Online Comment

Application H19-0782-16
Location ASHTREE FARM 92 GUANOCKGATE ROAD SUTTON ST EDMUND
PE12 0LU
Proposal Proposed barn conversion

Name J Reith
Address Environmental Health Technician Safety and Environment

Drawing
FLOOR PLANS & ELEVATIONS - EXISTING
LOCATION PLAN - EXISTING

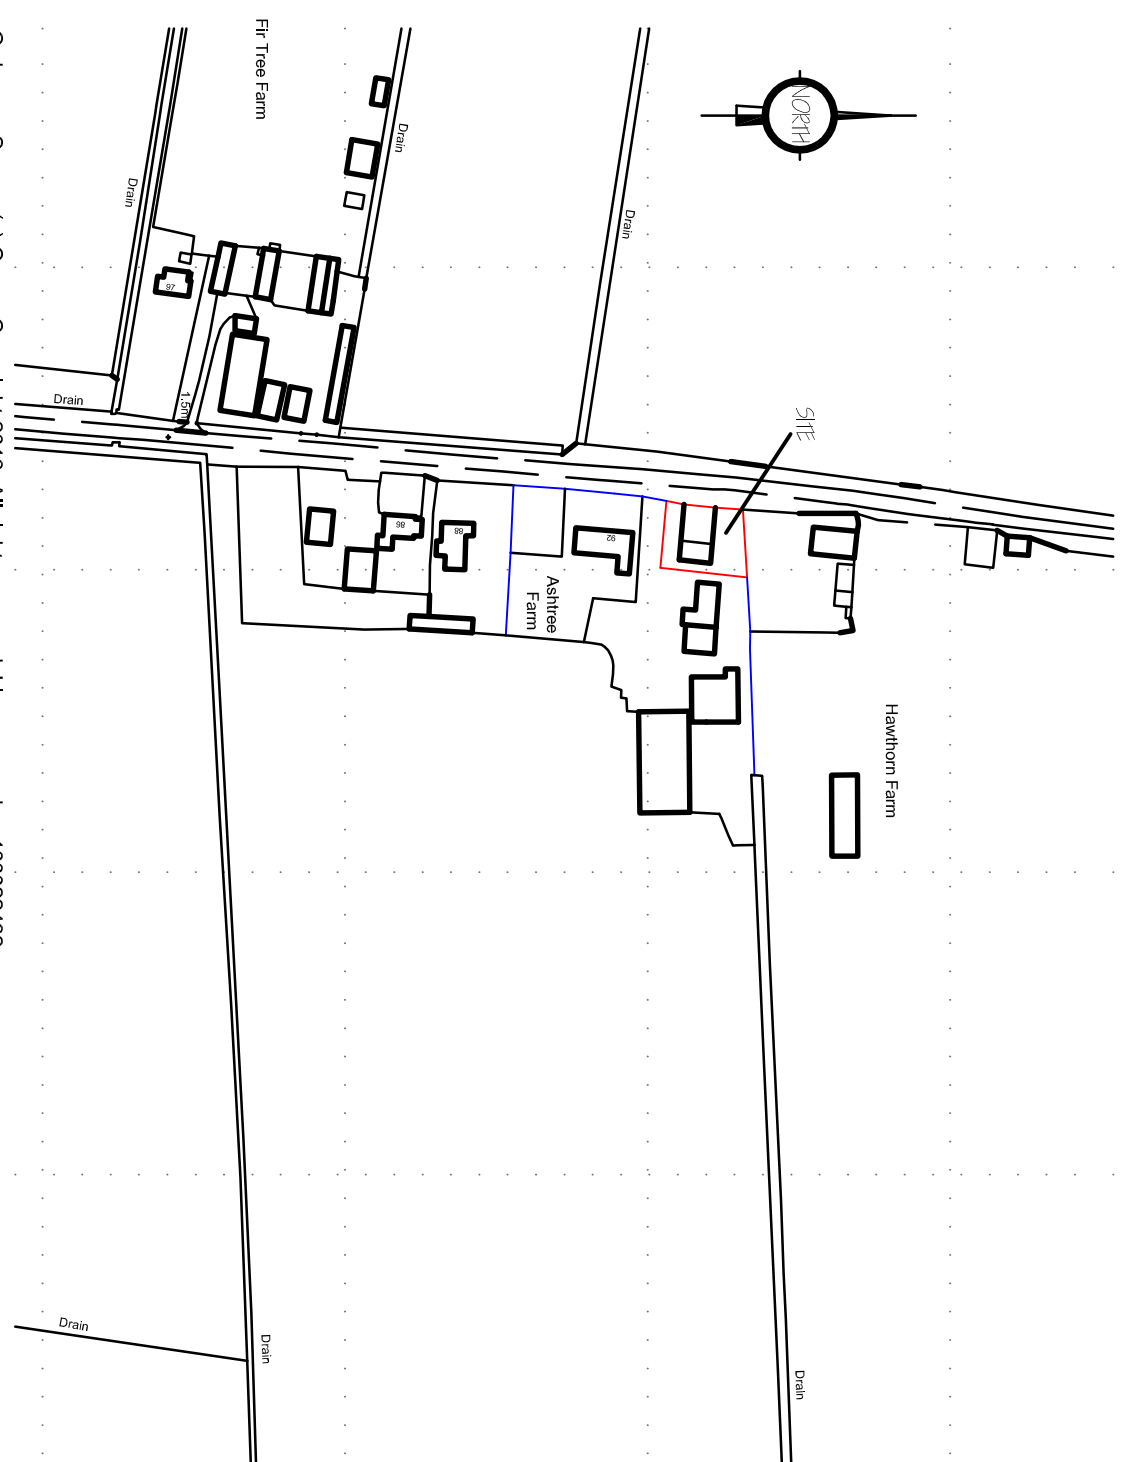
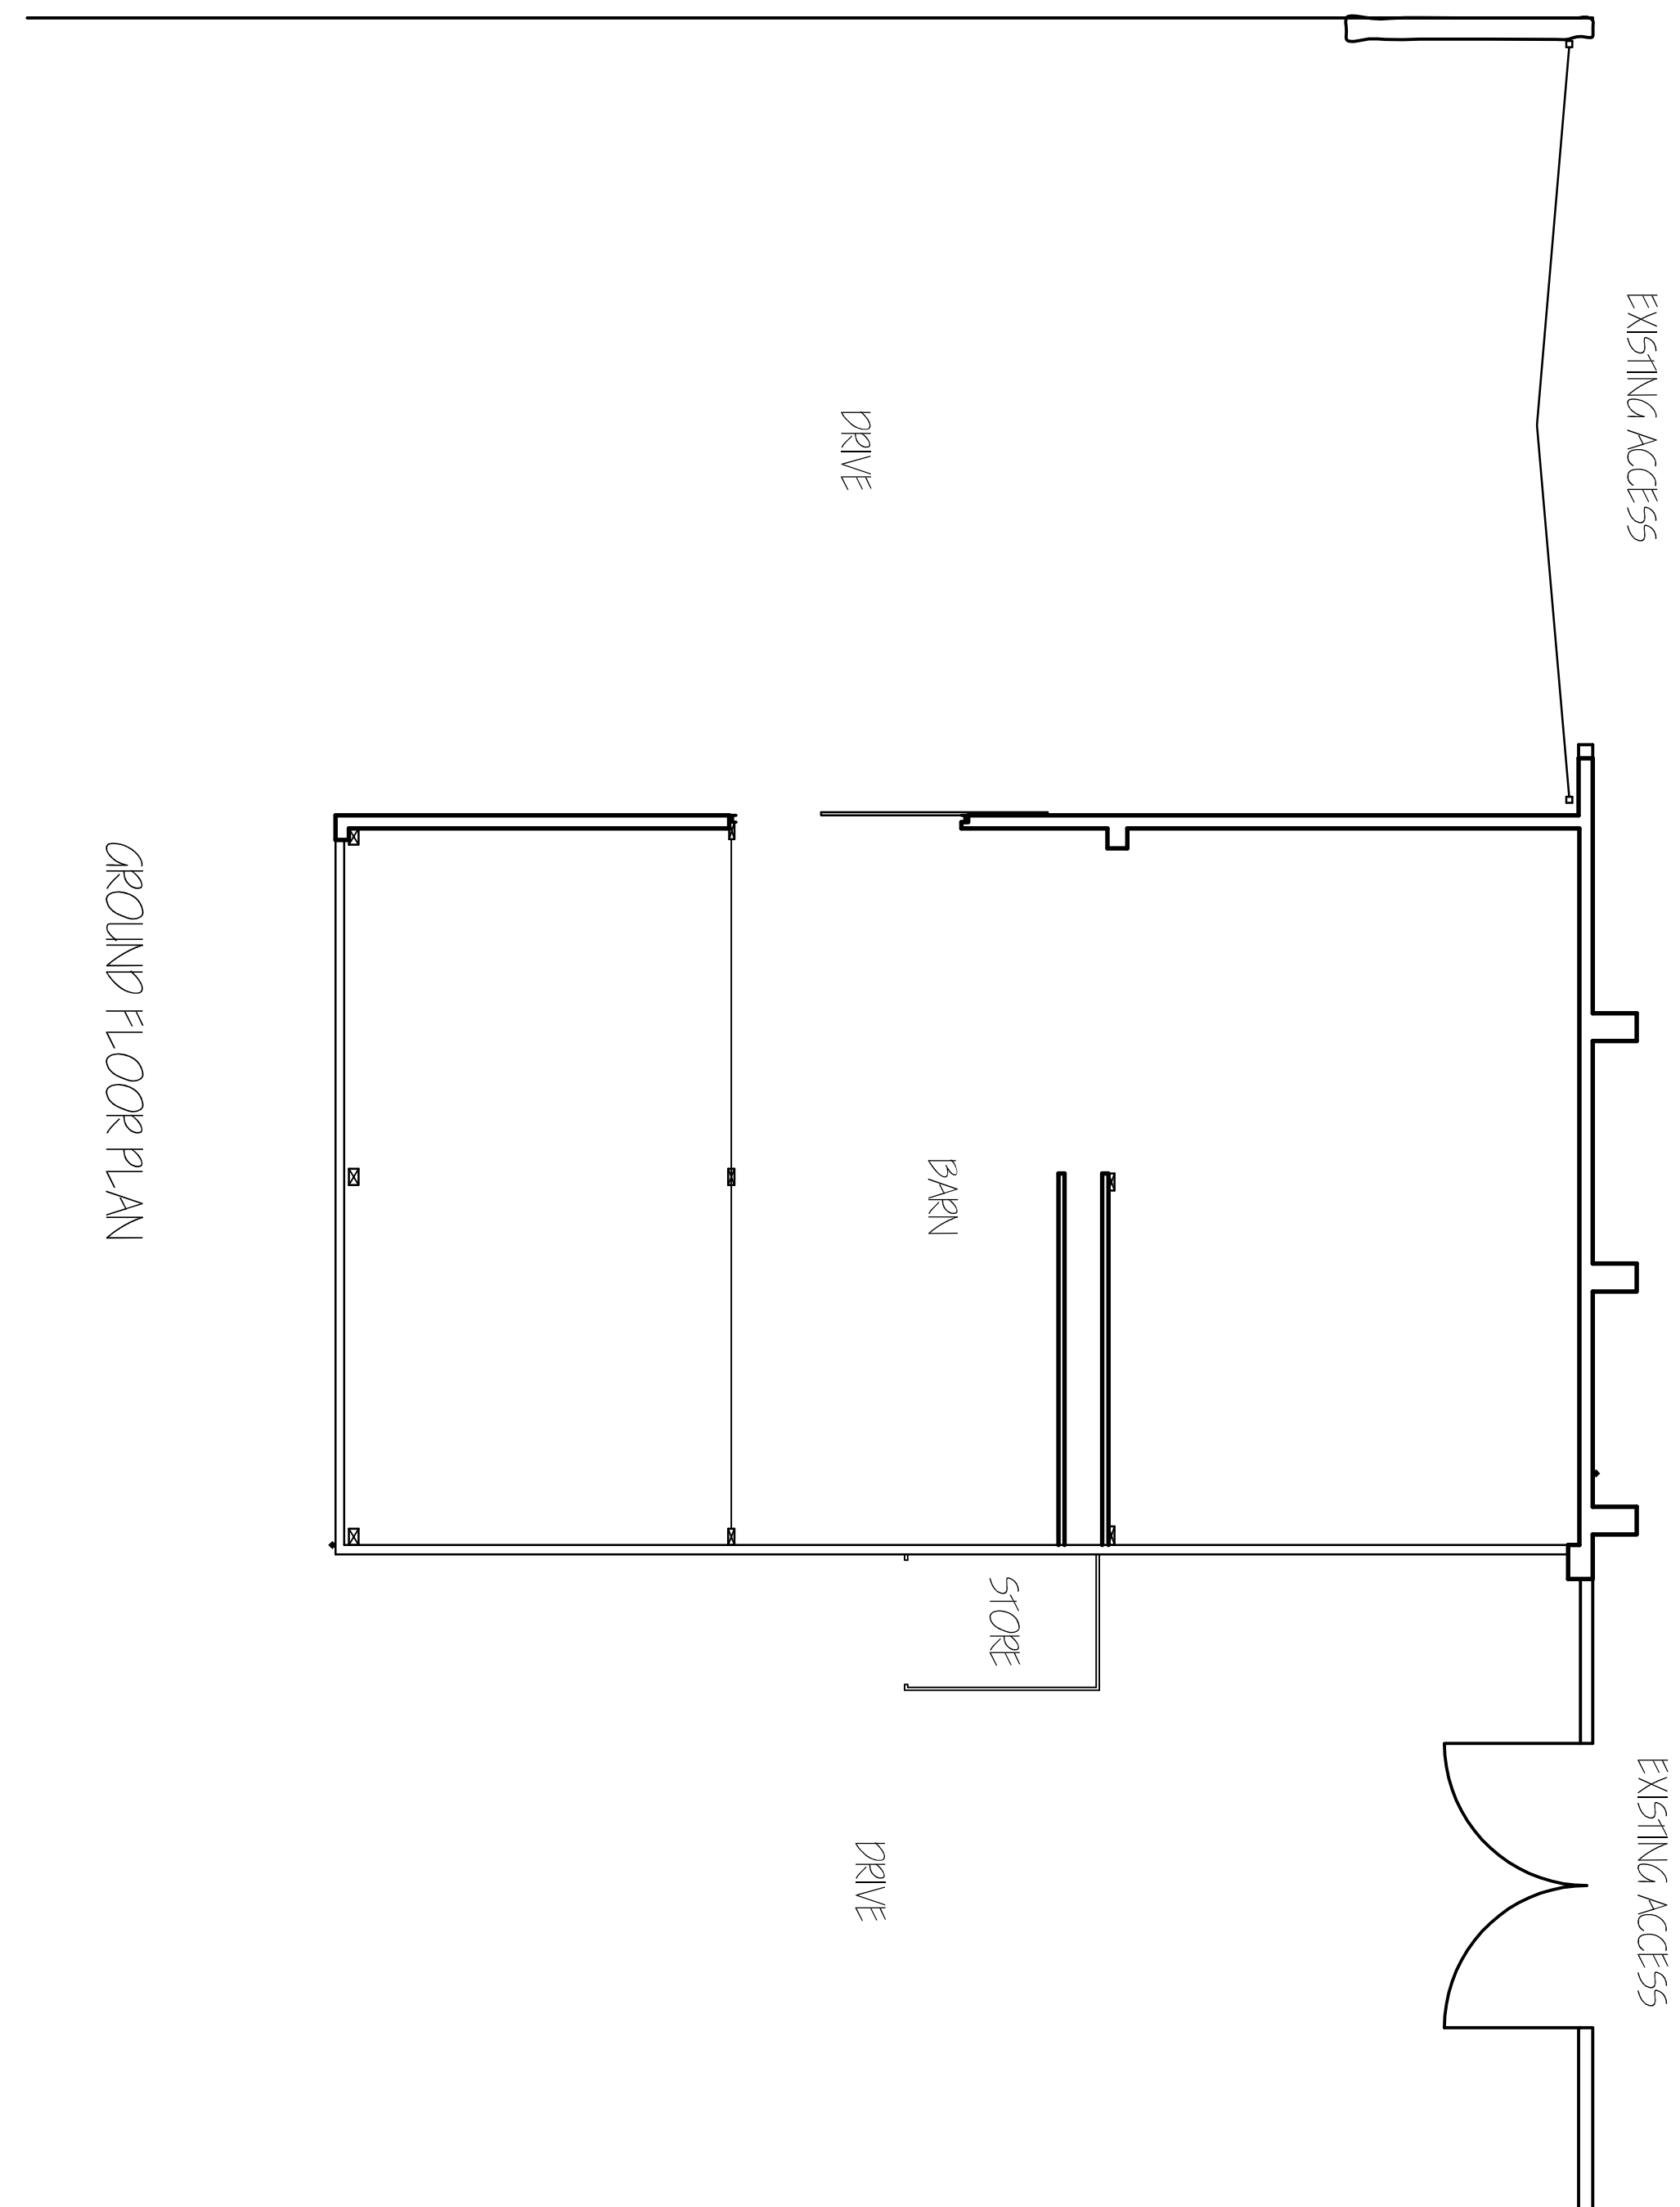
Due to the previous agricultural use of this site I request the full contaminated land condition for this application in order to protect the end user. I note that the existing building contains asbestos containing materials which must be dealt with appropriately.
